LSC TRANSPORTATION CONSULTANTS, INC.
545 East Pikes Peak Avenue, Suite 210
Colorado Springs, CO 80903
(719) 633-2868
FAX (719) 633-5430
E-mail: lsc@lsctrans.com
Website: <http://www.lsctrans.com>

MEMORANDUM

SUBJECT: Lorson Ranch East
(PUDSP-16-003) Review 2
Response to Comments Memorandum
LSC #164360

Following are the LSC Transportation Consultants, Inc. responses to the August 15, 2017 El Paso County Planning and Community Department comments letter regarding the July 12, 2017 Updated Traffic Impact and Access Analysis by LSC.

Figure 9

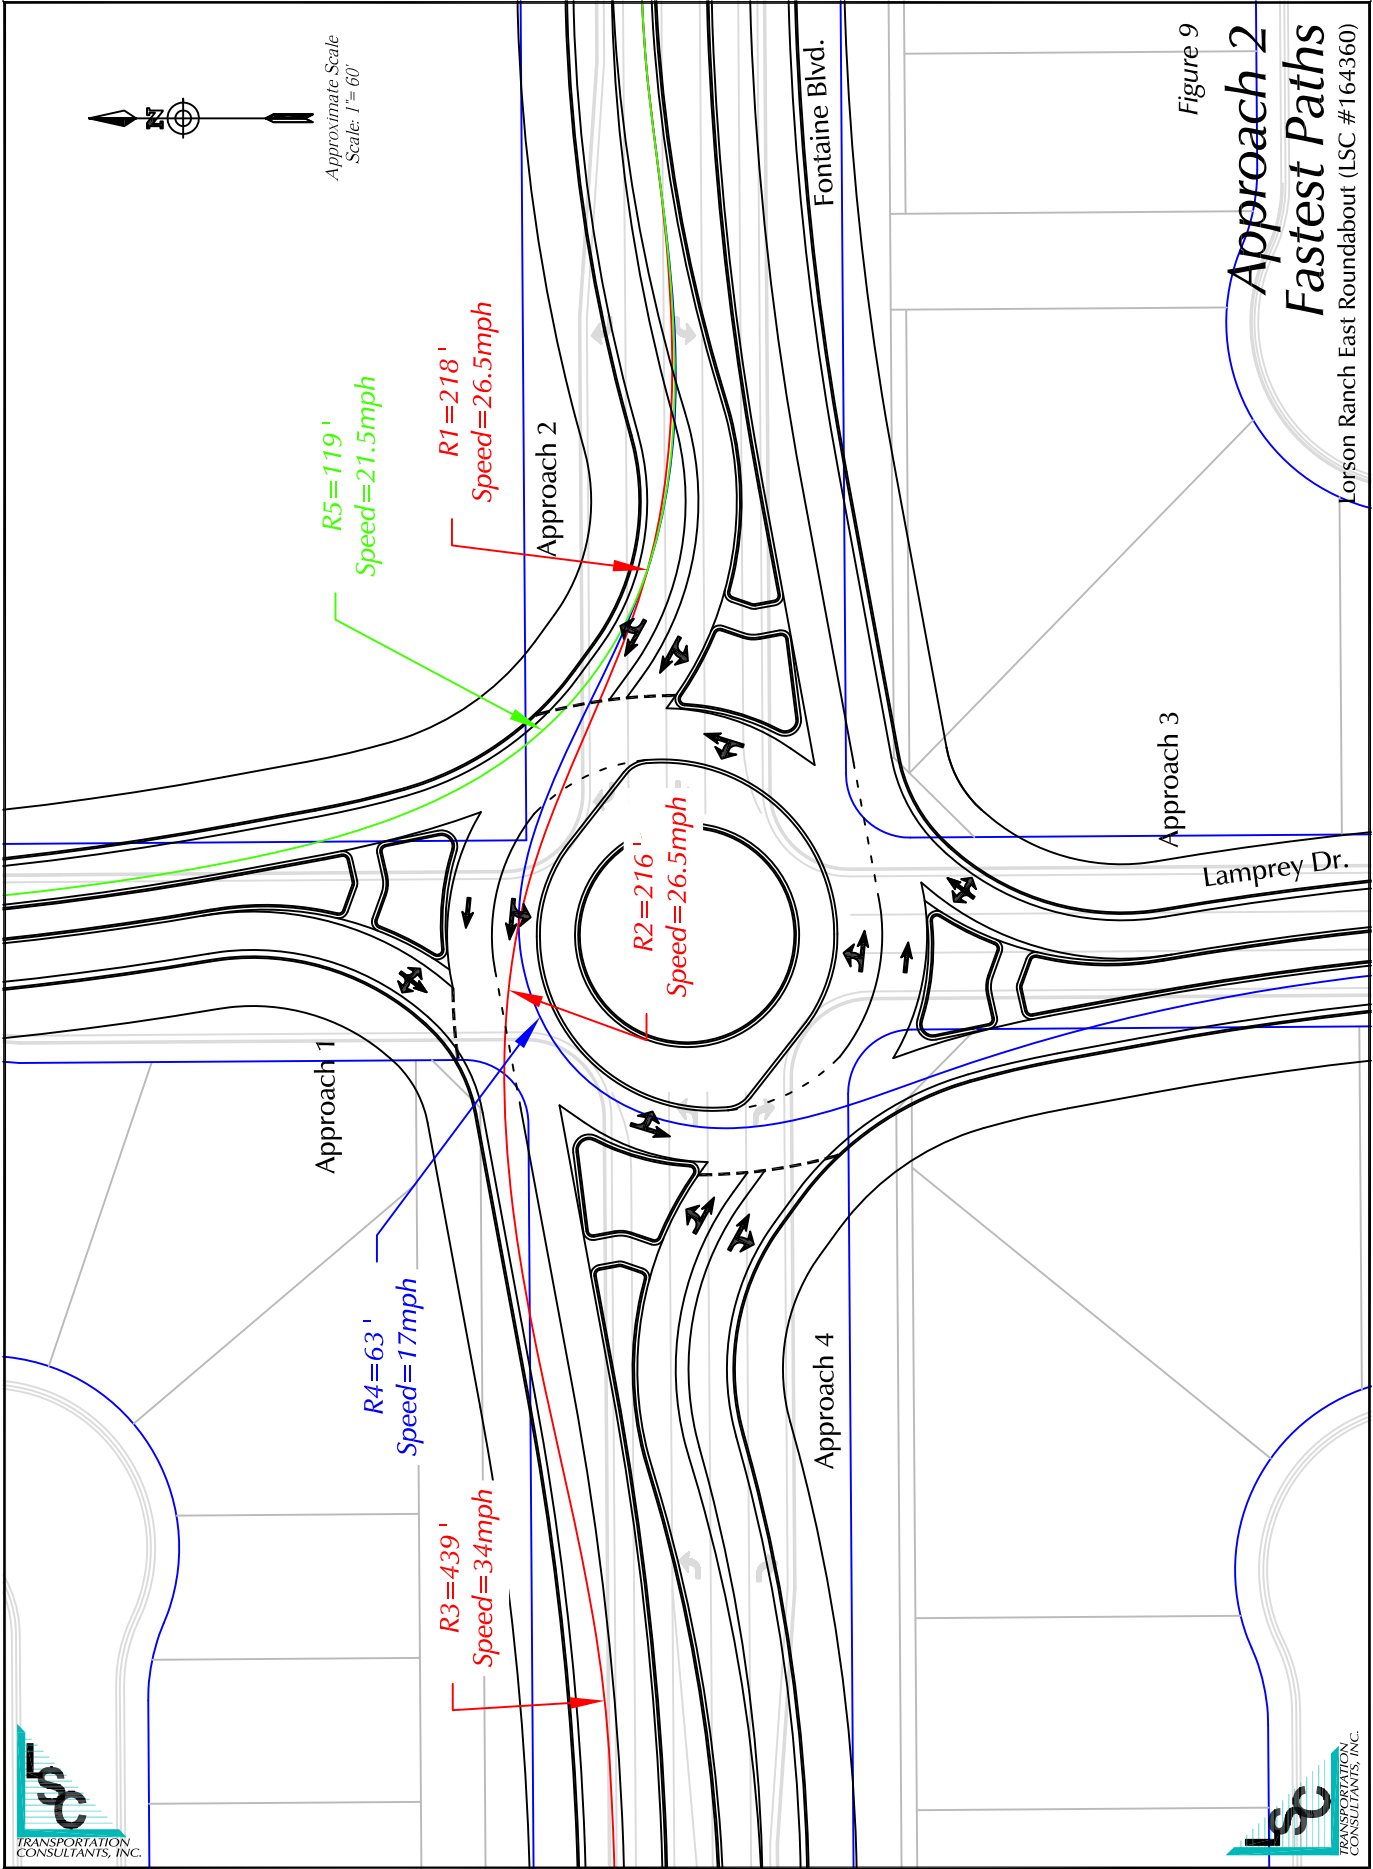
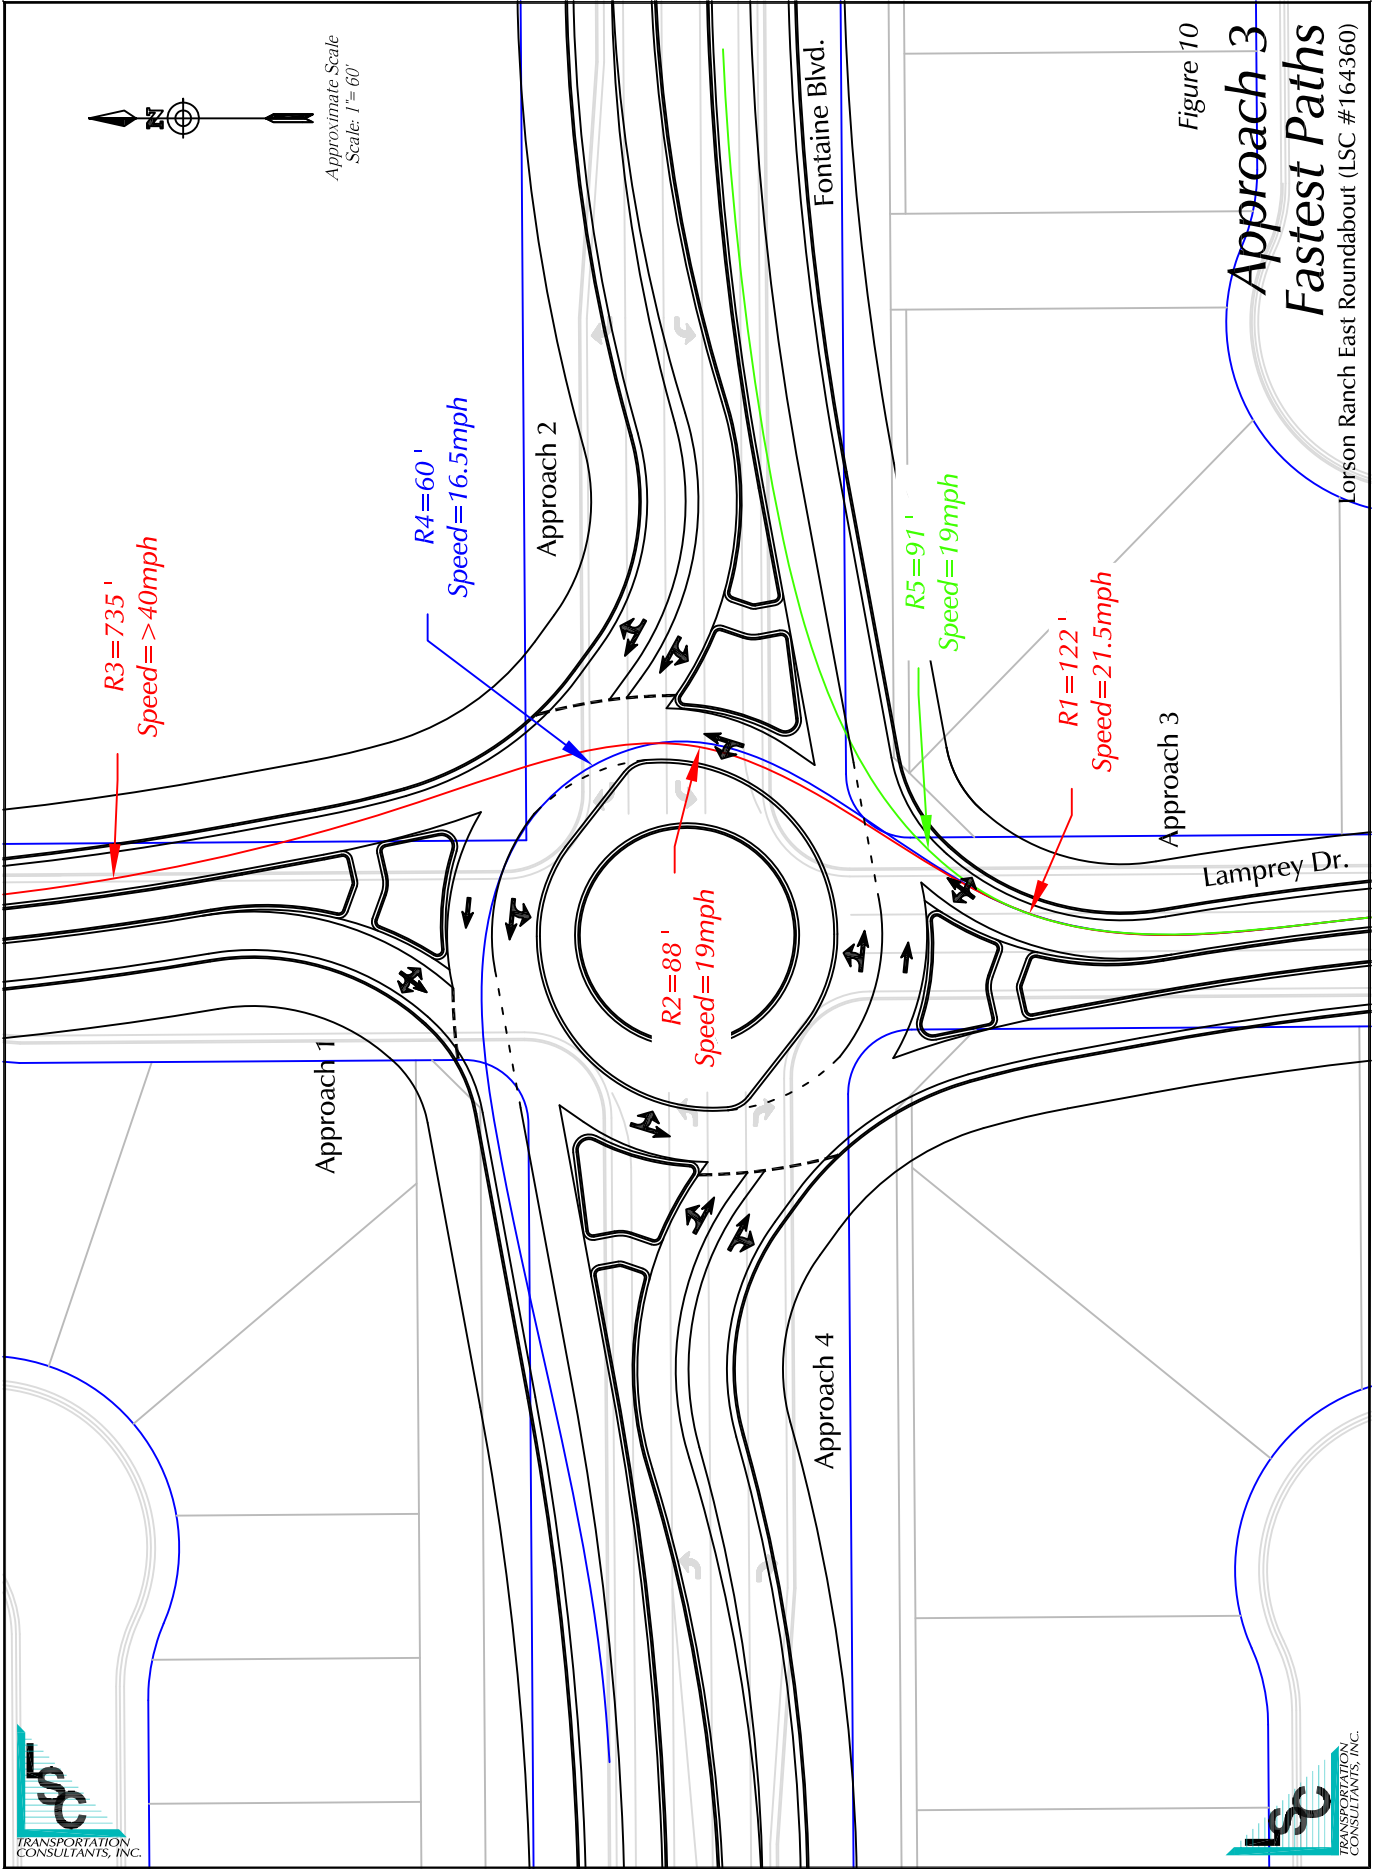
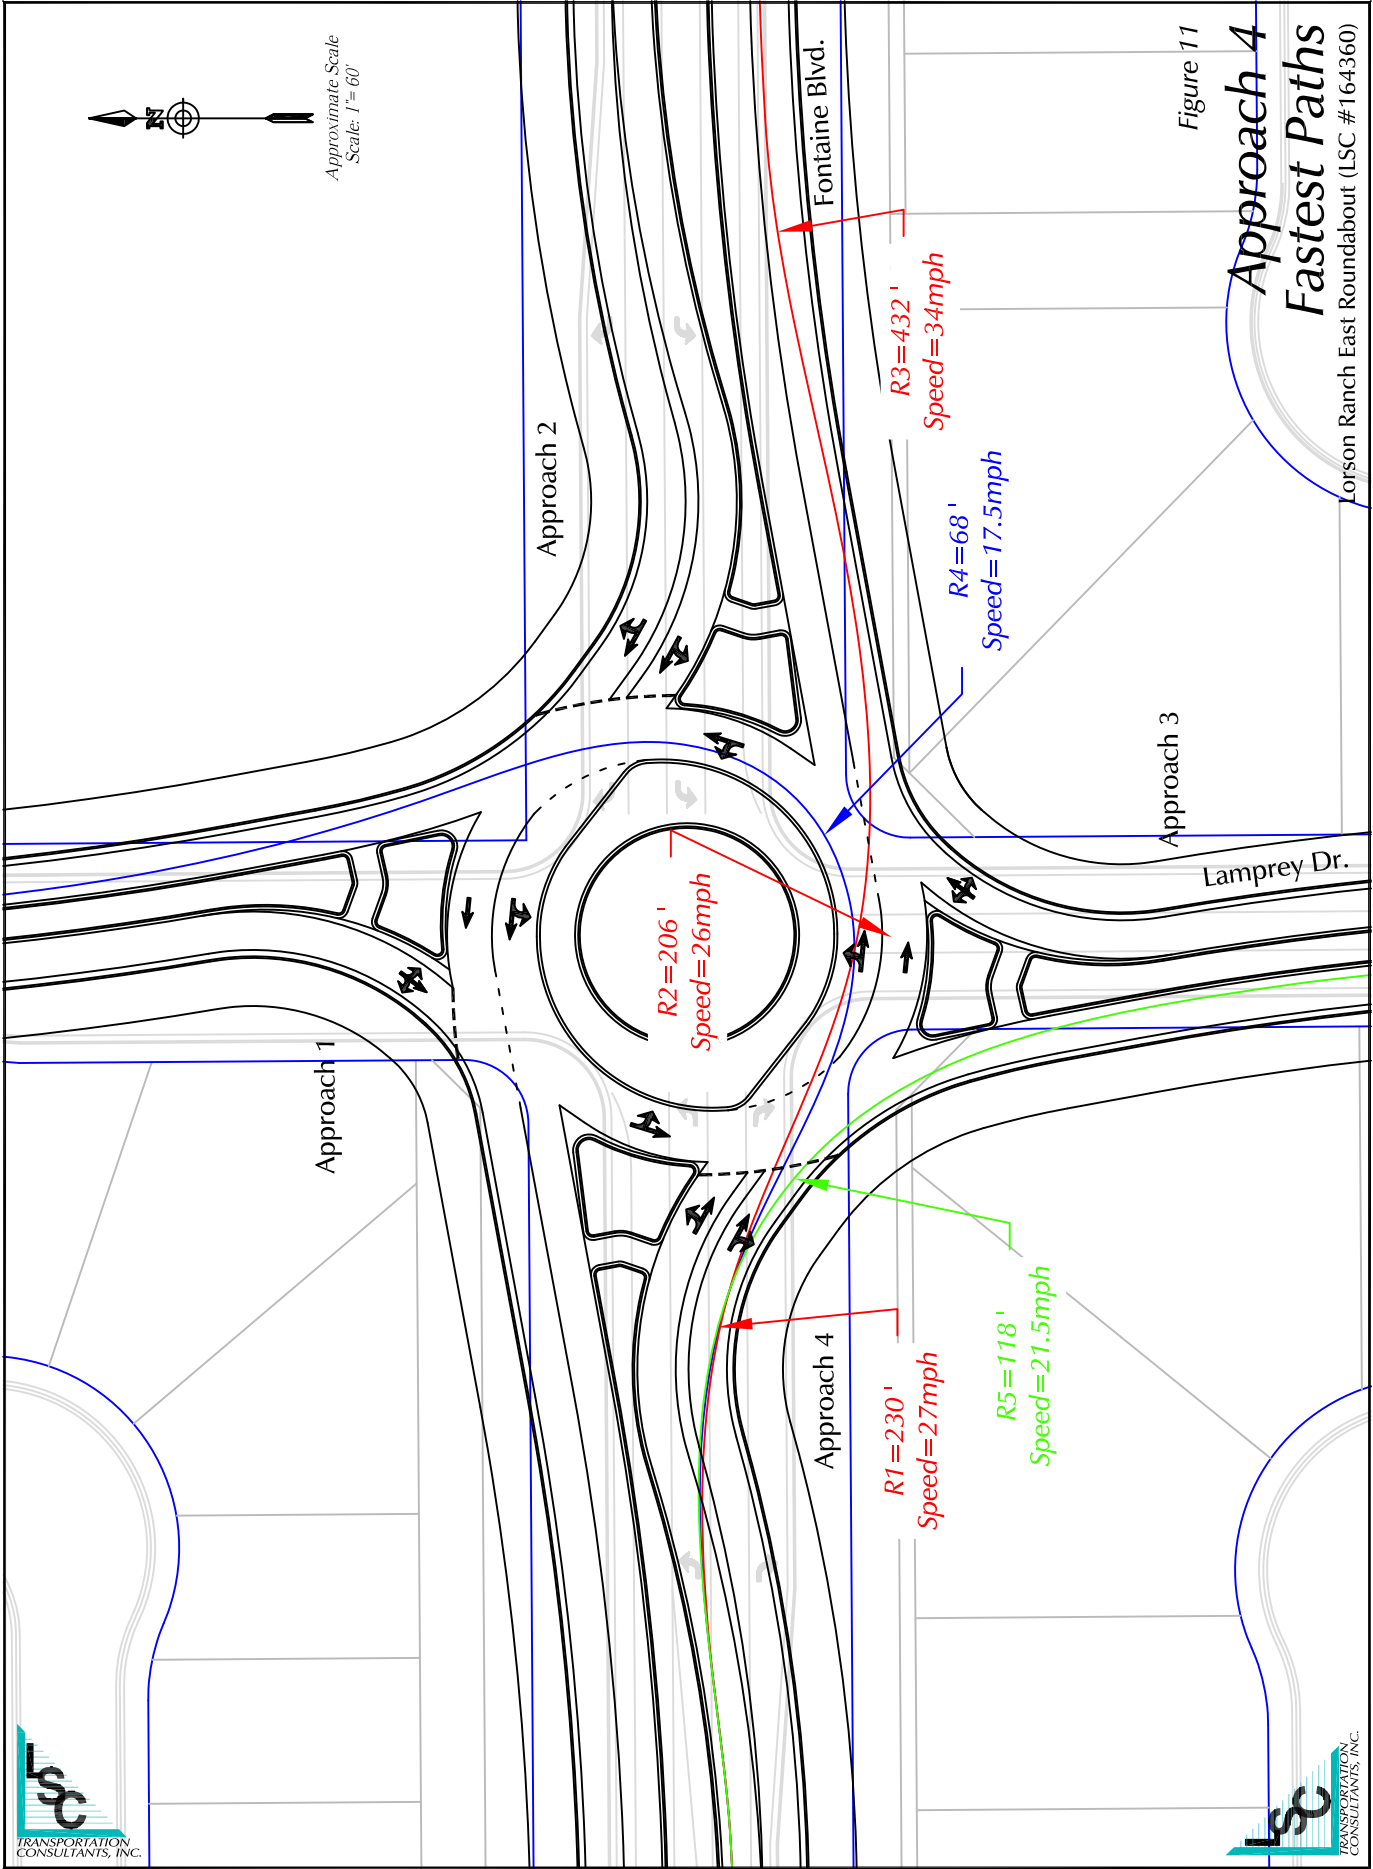
8. *Regarding the e-mailed comments dated March 17, 2017:*
*a. **It needs to be clearly documented that the roundabout is the proposed intersection at Lamprey/Fontaine. If the roundabout is the chosen option, could it not be designed to be expandable to 2-lanes when necessary along with widening of Fontaine Blvd.?***

LSC Response: The updated TIS clarifies this and clearly presents the roundabout as the proposed solution. The report also includes a roundabout design report and exhibits with the design of a future two-lane roundabout.
